OXFORDSHIRE COUNTY COUNCIL'S RESPONSE TO CONSULTATION ON THE FOLLOWING DEVELOPMENT PROPOSAL

Application no: 22/02101/OUT

Proposal: Outline planning application for a residential development comprising up to 250 dwellings (with up to 30% affordable housing), public open space, landscaping and associated supporting infrastructure. Means of vehicular access to be determined via Edinburgh Way, with additional pedestrian and cycle connections via Dover Avenue and Balmoral Avenue. Emergency access provision also via Balmoral Avenue. All other matters reserved

Location: Land Adjoining Withycombe Farmhouse, Stratford Road A422, Drayton

**Figure 4-1: Access Strategy**

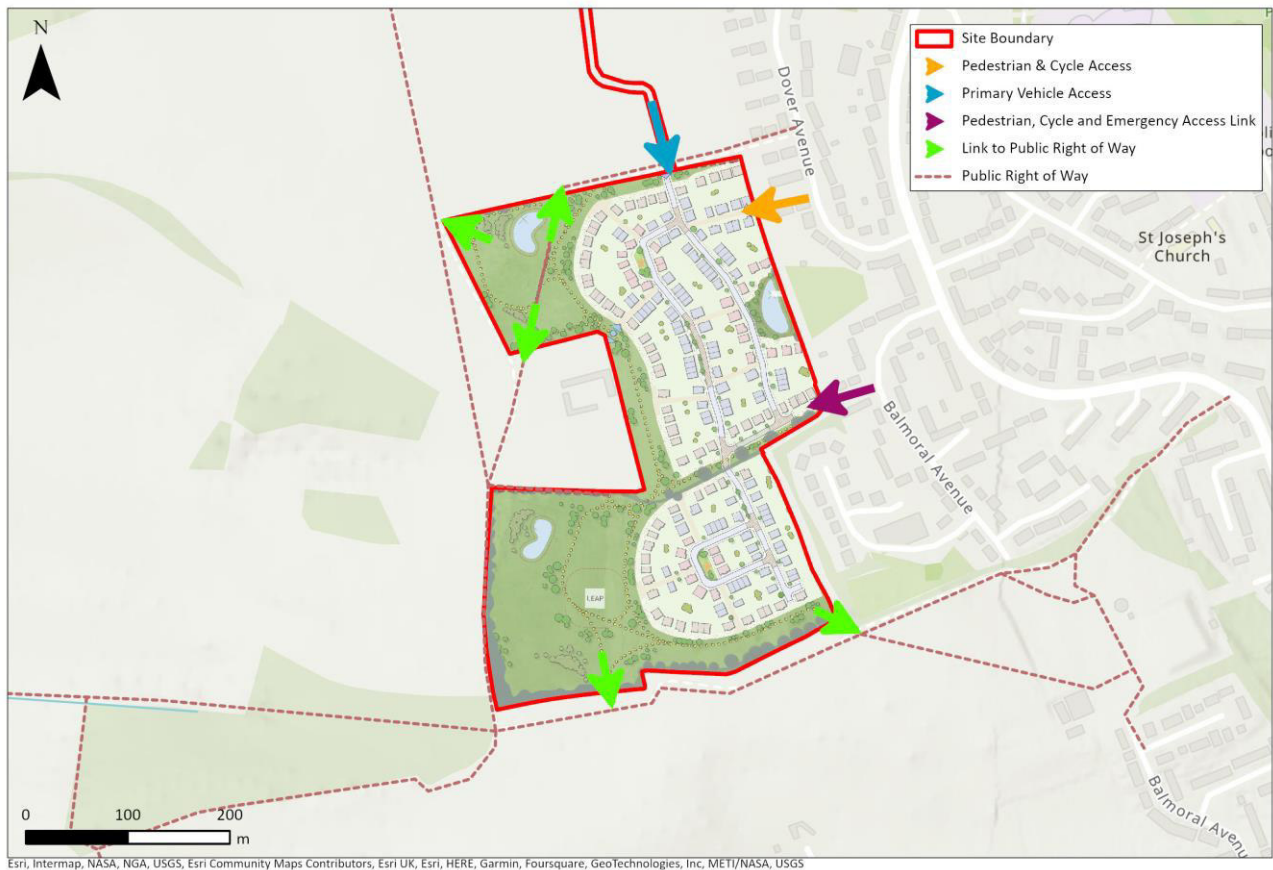
The site is accessed through the consented Banbury Rise development (planning application ref: 13/00444/OUT) via two primary vehicular accesses; Bailey Road to the immediate north from the site and George Parish Road being the northern most access. George Parish Road in turn leads onto Bretch Hill while Bailey Road joins the highway at Edinburgh Way. Although the Highway Authority (HA) has technically approved for construction, the Banbury Rise internal roads including Bailey Road and George Parish Road, these may not yet be adopted highway.

The '*Parameter plan - Movement*' submitted for the outline planning application shows that the primary road (for Banbury Rise) runs between what is now Bailey Road and George Parish Road. Other estate roads were hence designed as secondary and tertiary roads. I note that development traffic shall be able to route through Wilson Road, Longley Crescent and Lunnun Road to connect onto Bailey Road. My concern therefore is borne from this aspect - the section of carriageway between the site and Bailey Road. How convenient is it for 137+250 properties to acquire access through this section that was initially designed as access only for 137?

Appended to the TA is the vehicle tracking exercise plan (WE088-EN-102C). This has not been tracked with two cars passing each other. Also, it becomes apparent that the refuse vehicle would barely leave sufficient room for cars to pass even on the straight sections. The additional 250 properties will intensify the need for such occurrences, which would lead to vehicles mounting the kerbs - which is a safety risk to pedestrians and also damage to infrastructure. **(Reason for objection)**

In addition to the width constraints above, I note that a high proportion of properties (within the Banbury Rise development) along the access route are designed with tandem parking. Tandem parking is usually associated with increased amount of manoeuvres which often require momentarily parking on the adjacent carriageway if only the inner vehicle needs to be driven away. This would lead to on-street parking for longer periods than needed because residents over time find it exhausting to maintain the short durations. This street parking would create unwanted and unacceptable pressure on the route which has not been captured in the assessment.

The applicant has undertaken operational assessment on various junctions in the vicinity of the proposed development site. I am however, concerned by the fact that the application had excluded the northern Banbury Rise access (George Parish Road) from the capacity assessment exercise whilst still acknowledging that a proportion of the development traffic shall route through that access. Routing via the George Parish Road could either be incidental or pertaining to preference for those residents destined to/from the north and eastern areas of Banbury. Without this assessment, I consider the application has not fully appraised its impact on the network. **(Reason for objection)**

This can only be addressed by an obligation to be secured via a s106 agreement or grampian condition to implement waiting restrictions in the form of double yellow lines along the access route. Should the access route identified be adopted highway, then a TRO shall be required in order to accomplish this.

To address this, the application needs to include the George Parish Road/ Bretch Hill junction under various scenarios (sensitivity tests) in the horizon year. Such scenarios must include the following assumptions.

- 50% George Parish Road and 50% Bailey Road accesses
- 30% George Parish Road and 70 % Bailey Road
- 90% George Parish Road and 10% Bailey Road
